**CITY OF PORTLAND**

April 23, 1996

RE: 380 Cumberland Avenue

Your application to make interior renovations has been reviewed and a permit is herewith issued subject to the requirements listed below. This permit does not excuse the applicant from meeting applicable State and Federal laws.

380 CUMBERLAND AVE
2ND FLOOR RENOVATION
FOR "SPRINT"

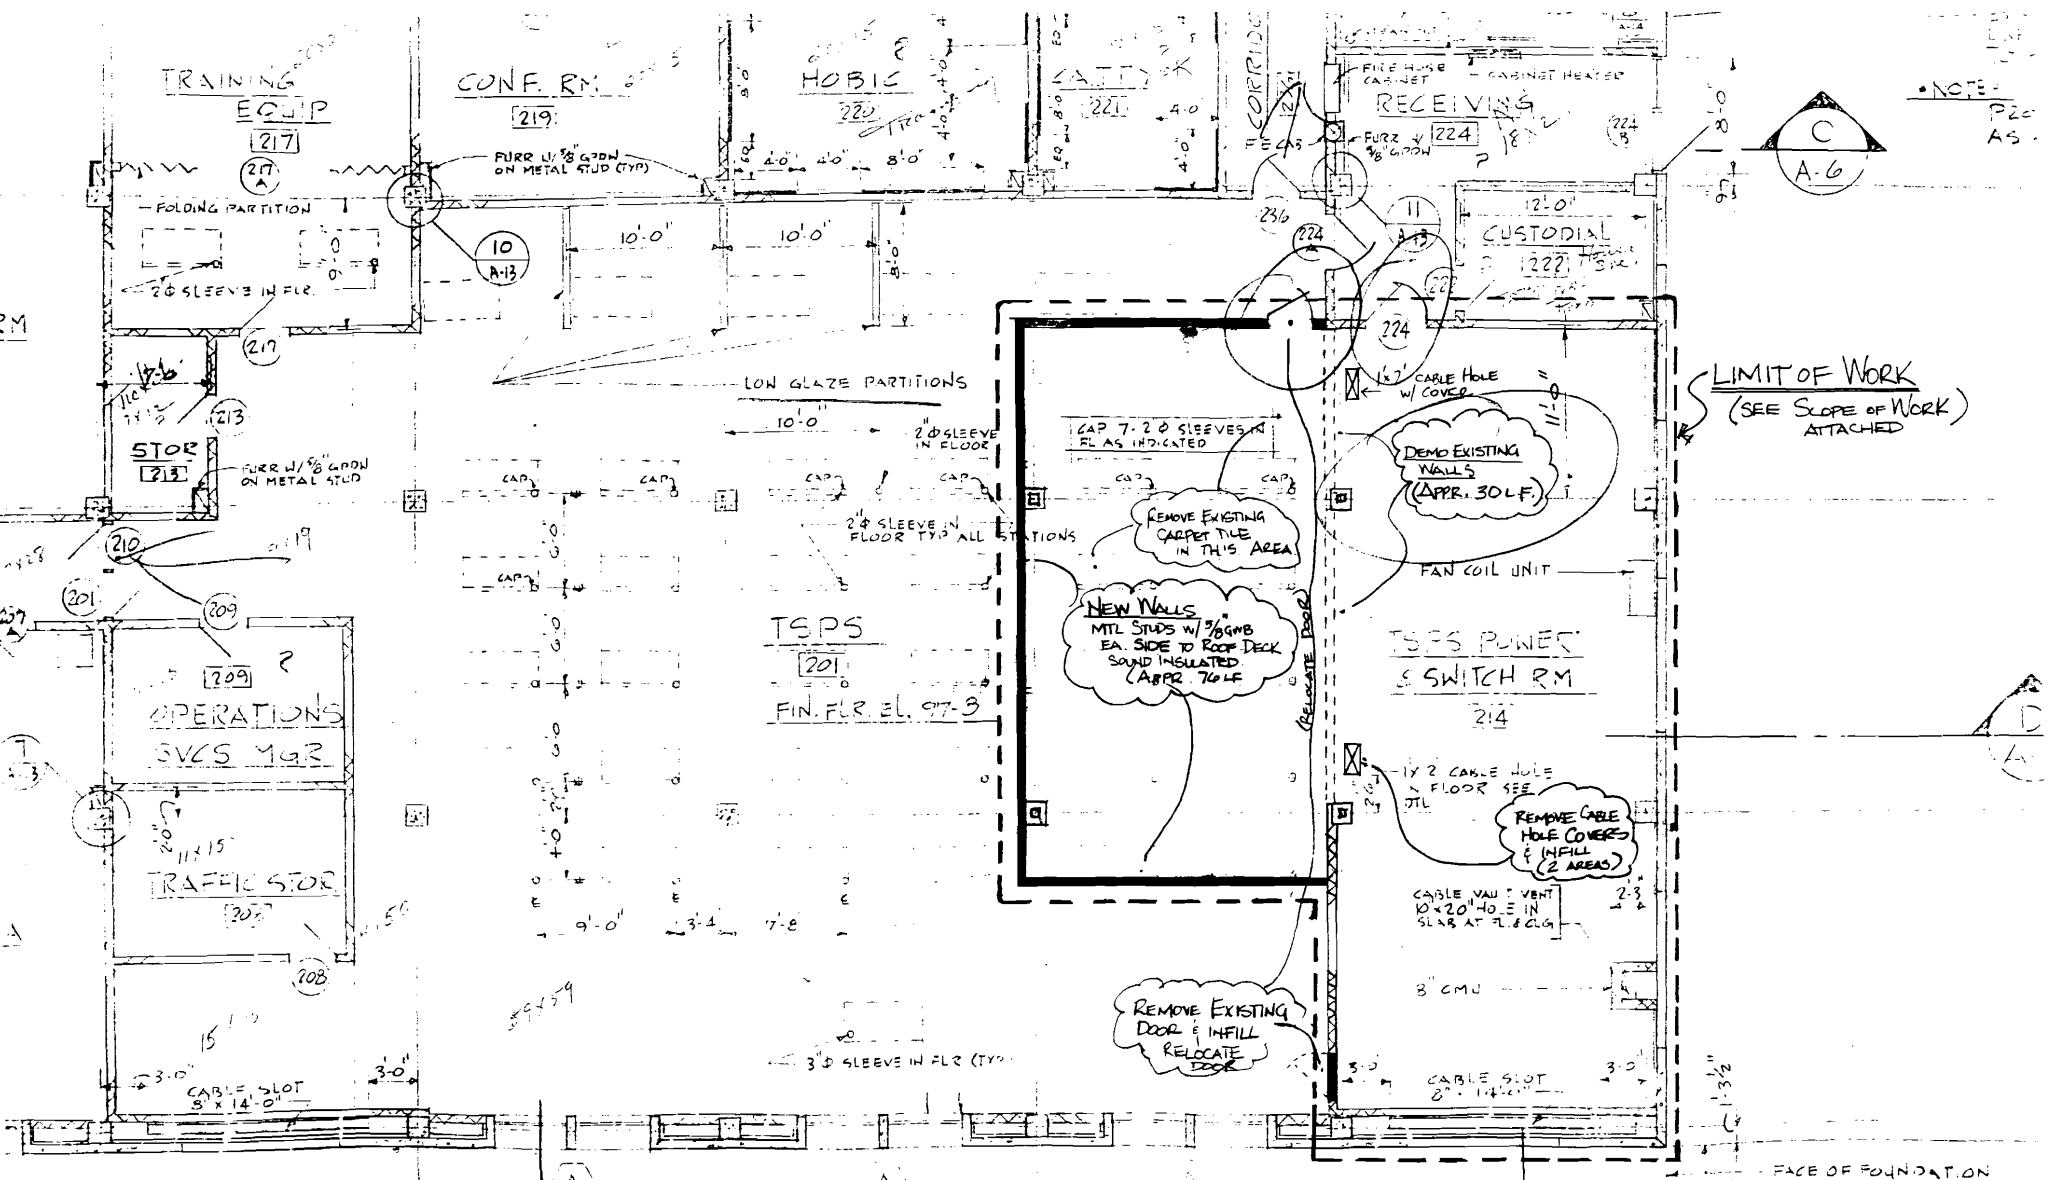
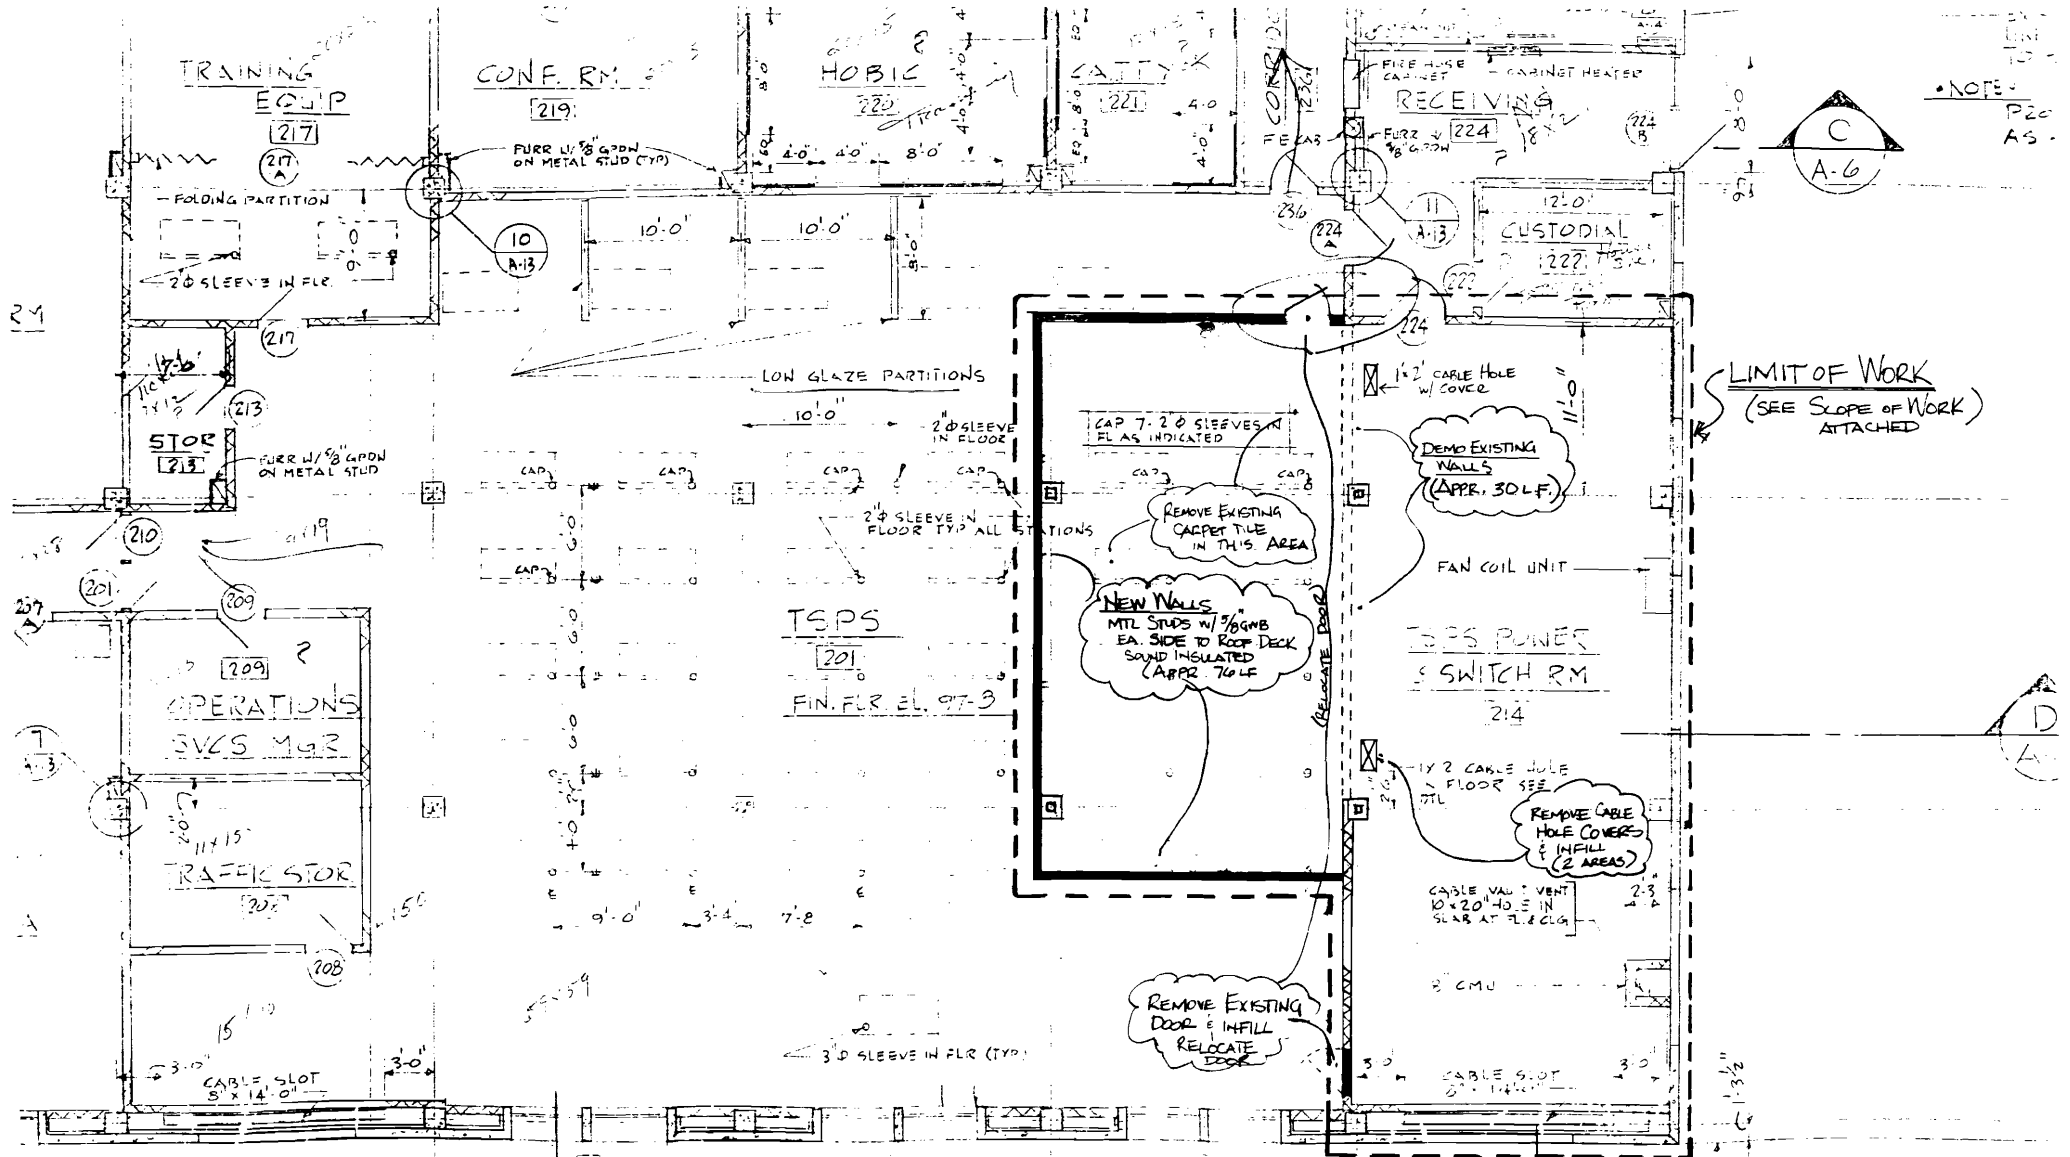
4. Your proposed plan shows the covering of a 1' x 2' cable hole. This covering must have the fire resistance rating of the floor ceiling assembly.
5. Glass and glazing shall be done in accordance with Chapter 24 of the City's Building Code (The BOCA National Building Code/1993)
